WEST SUSSEX COUNTY COUNCIL CONSULTATION

TO:	Arun District Council FAO: Anita Gardner
FROM:	WSCC - Highways Authority
DATE:	4 July 2022
LOCATION:	Land East of Roundstone Lane Angmering
SUBJECT:	A/268/21/PL Proposed car showroom and workshop with forecourt. This application is in CIL Zone (zero rated) as other development.
DATE OF SITE VISIT:	n/a
RECOMMENDATION:	No Objection
S106 CONTRIBUTION TOTAL:	n/a / £ See below for breakdown.

Drawing title  
Site Plan

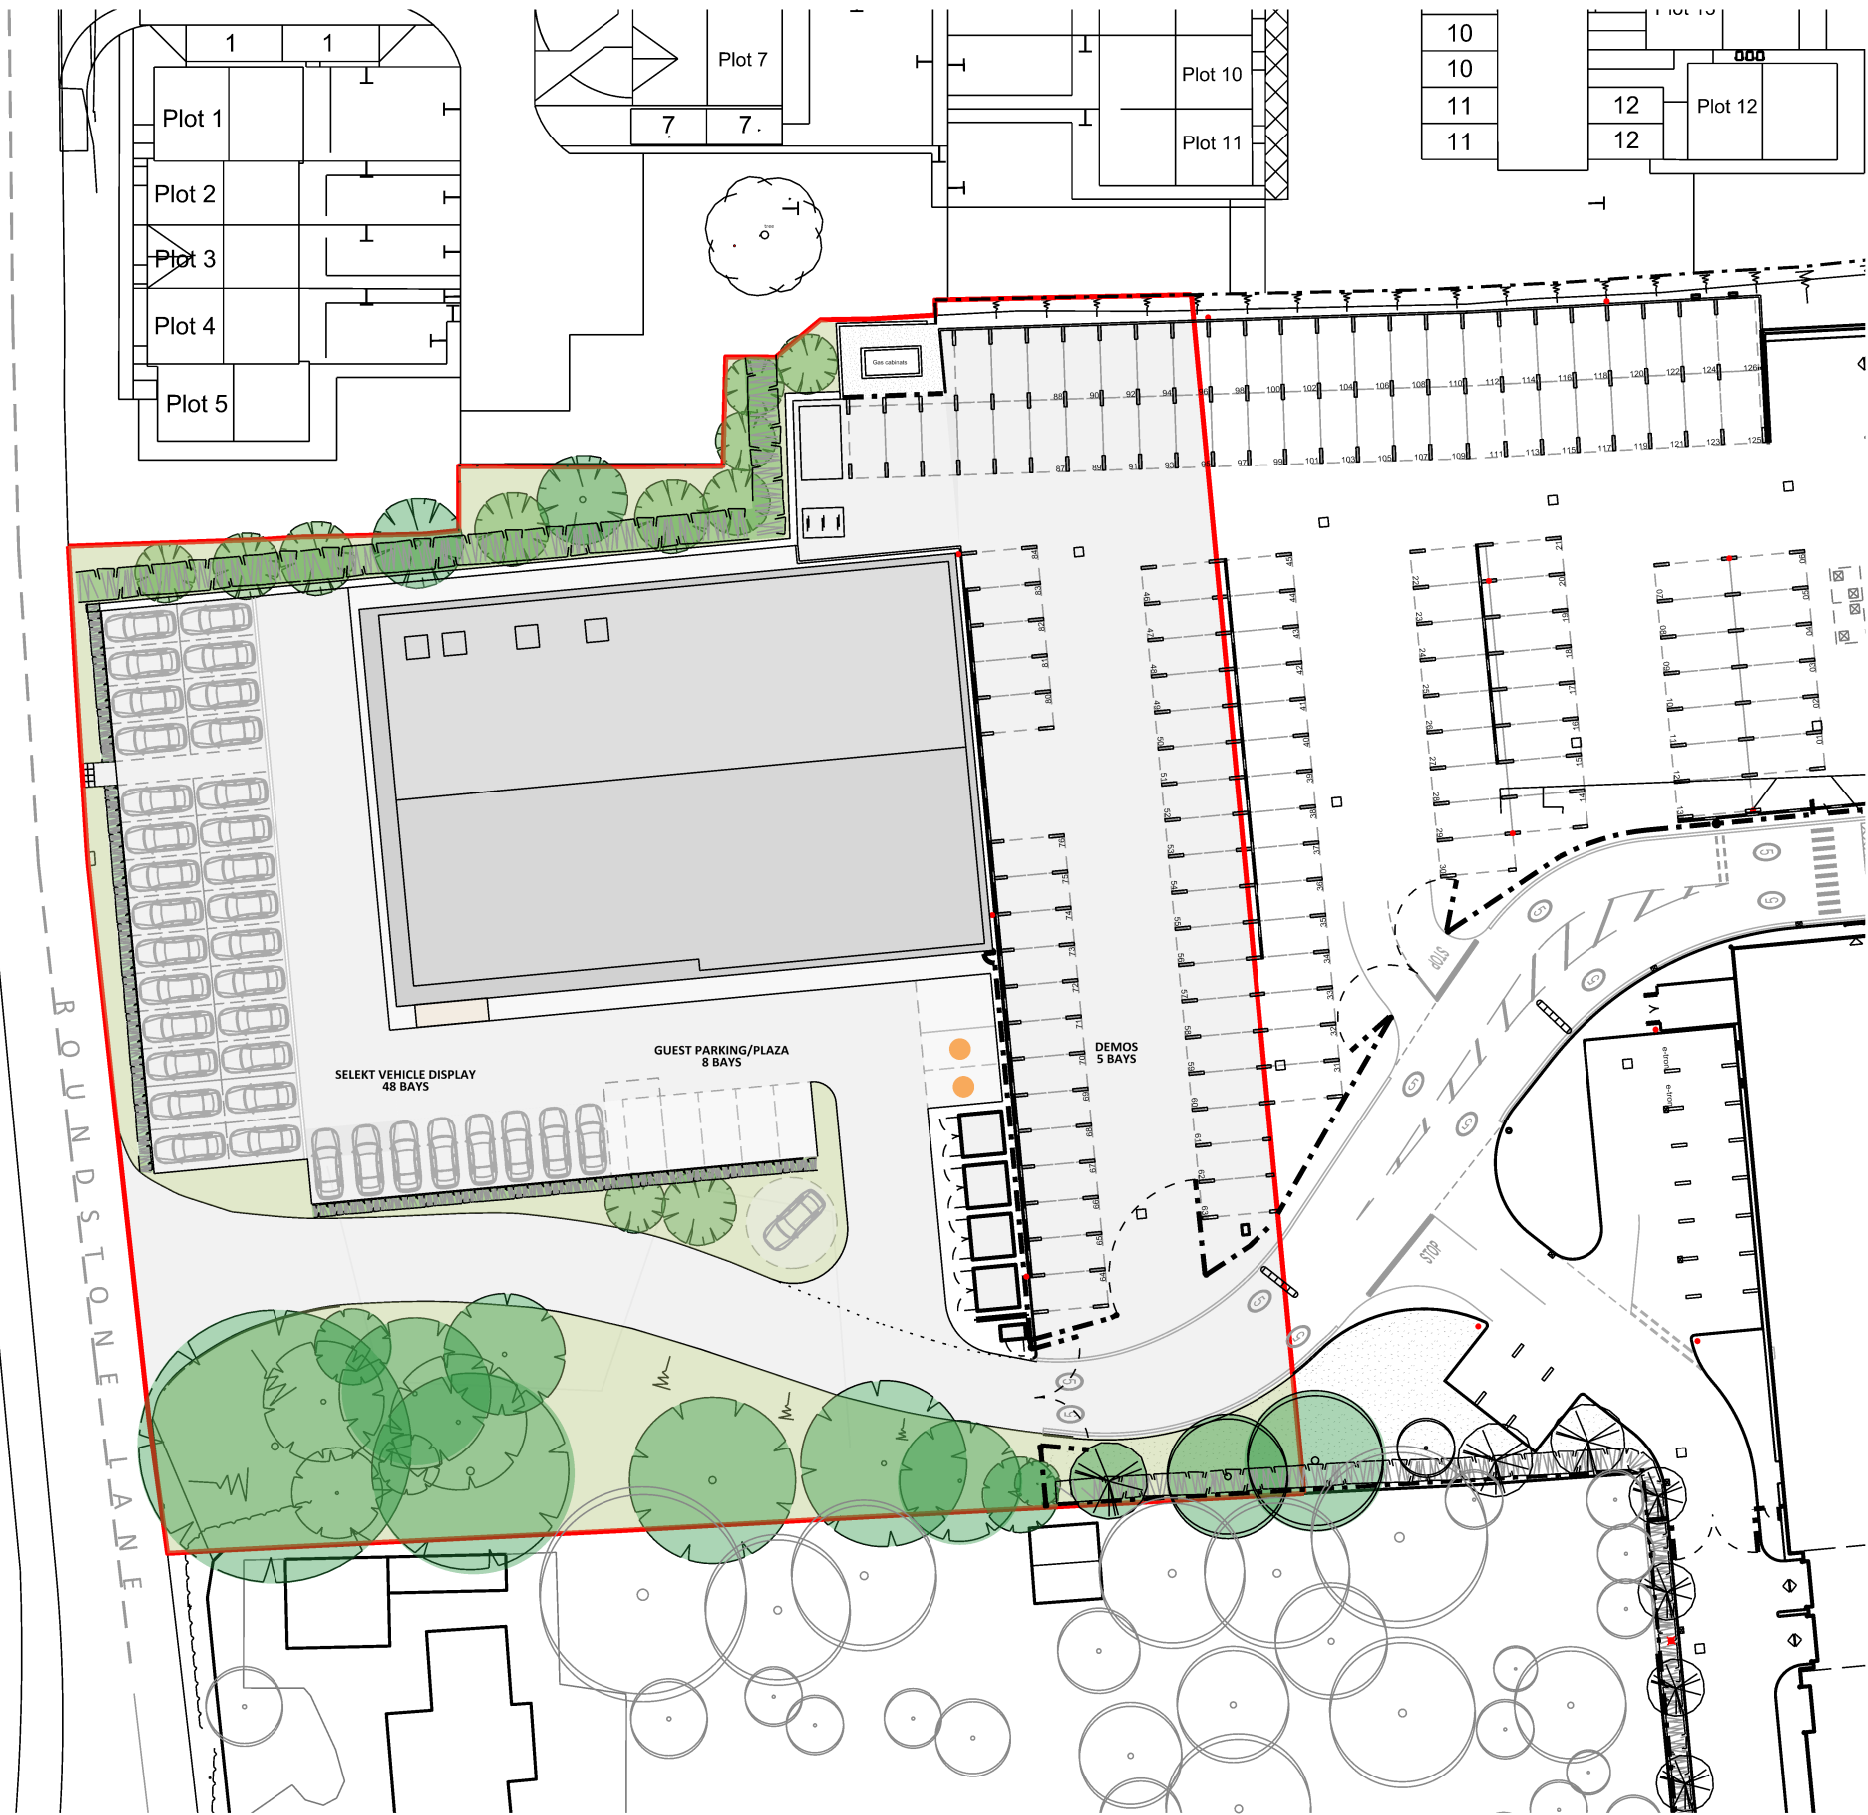
Further to our last response dated 08/02/2022. WSCC has received further updated plans regarding the proposed access arrangement, including details of the extent of the footway on the eastern side of Roundstone Lane, informal crossing point south of the existing bus stop, and double yellow lines either side of the access road and bell mouth junction.

The site access will need a s278 agreement as changes to the surfacing and off site highway works including the extension of the eastern footway across the frontage of the site, and informal dropped crossing will be required.

A TRO will also need to be progressed around the bellmouth of the access, where the highway meets the private road.

Details of footway construction will also be required, and should be submitted to the implementation team for approval, along with details of the dropped crossing on Roundstone Lane.
